KITTITAS COUNTY FIRE MARSHAL'S OFFICE

Re: Putnam (BL-11-000023)

After conducting a review of the above named project, I have the following comments:

PUTNAM/OSWALD BLA
SW 1/4, 6-19-17

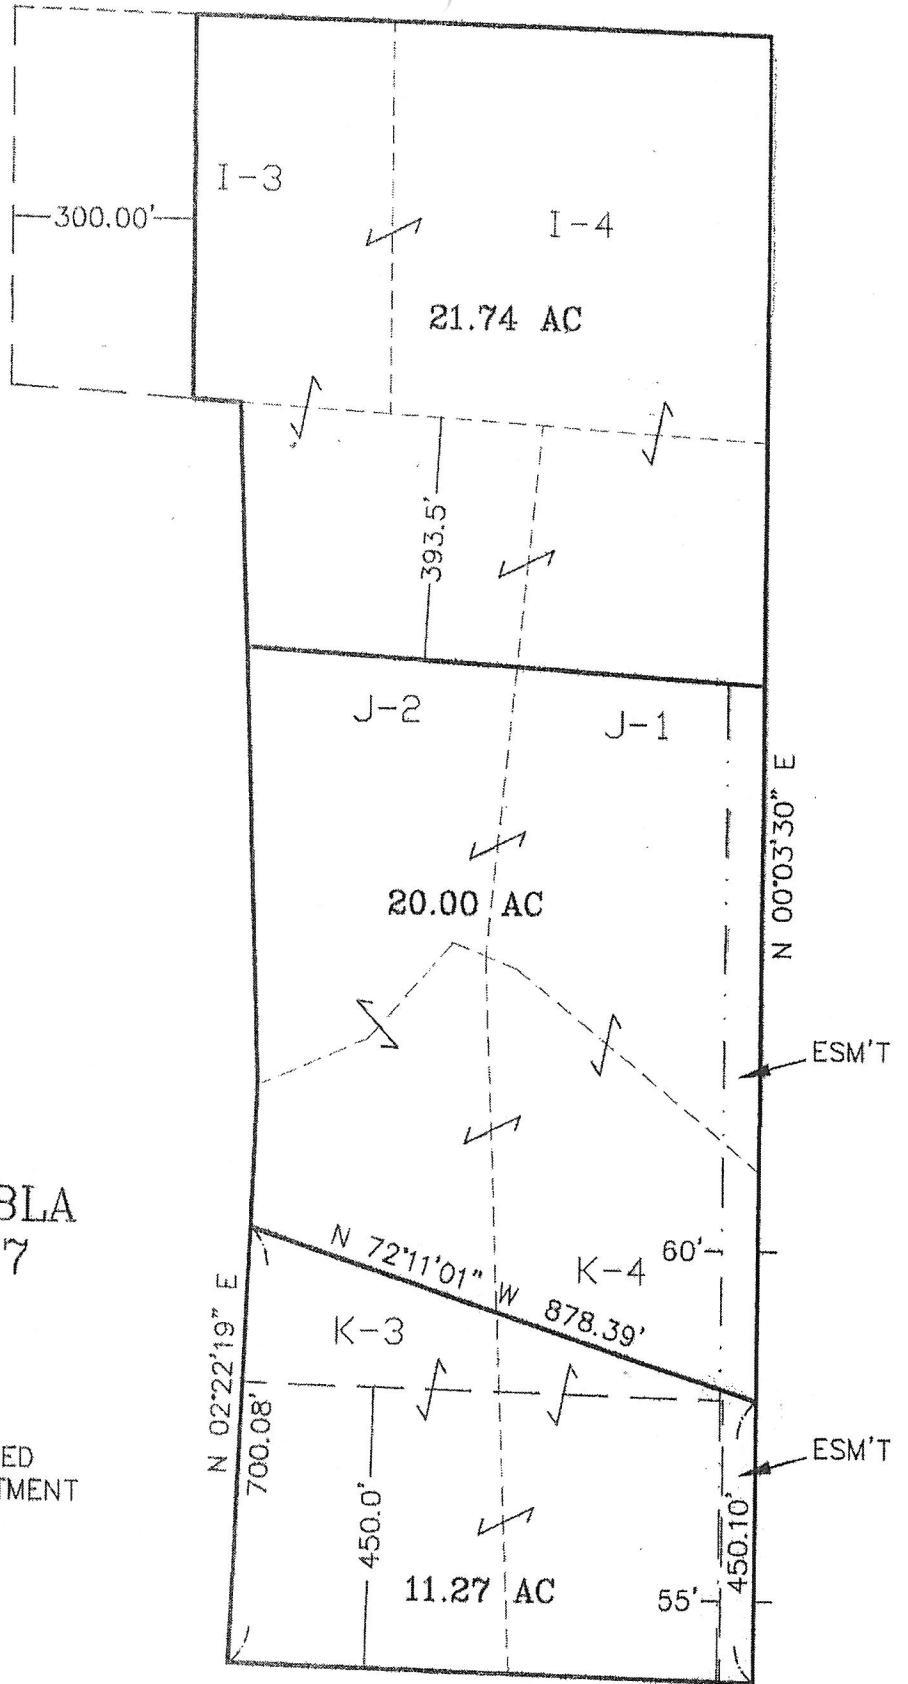
- Ensure that boundary line adjustments do not infringe upon existing structures, to include propane tanks, etc.
- Creation of any additional roads or access must comply with the International Fire Code.
- All future development must comply with the International Fire Code.
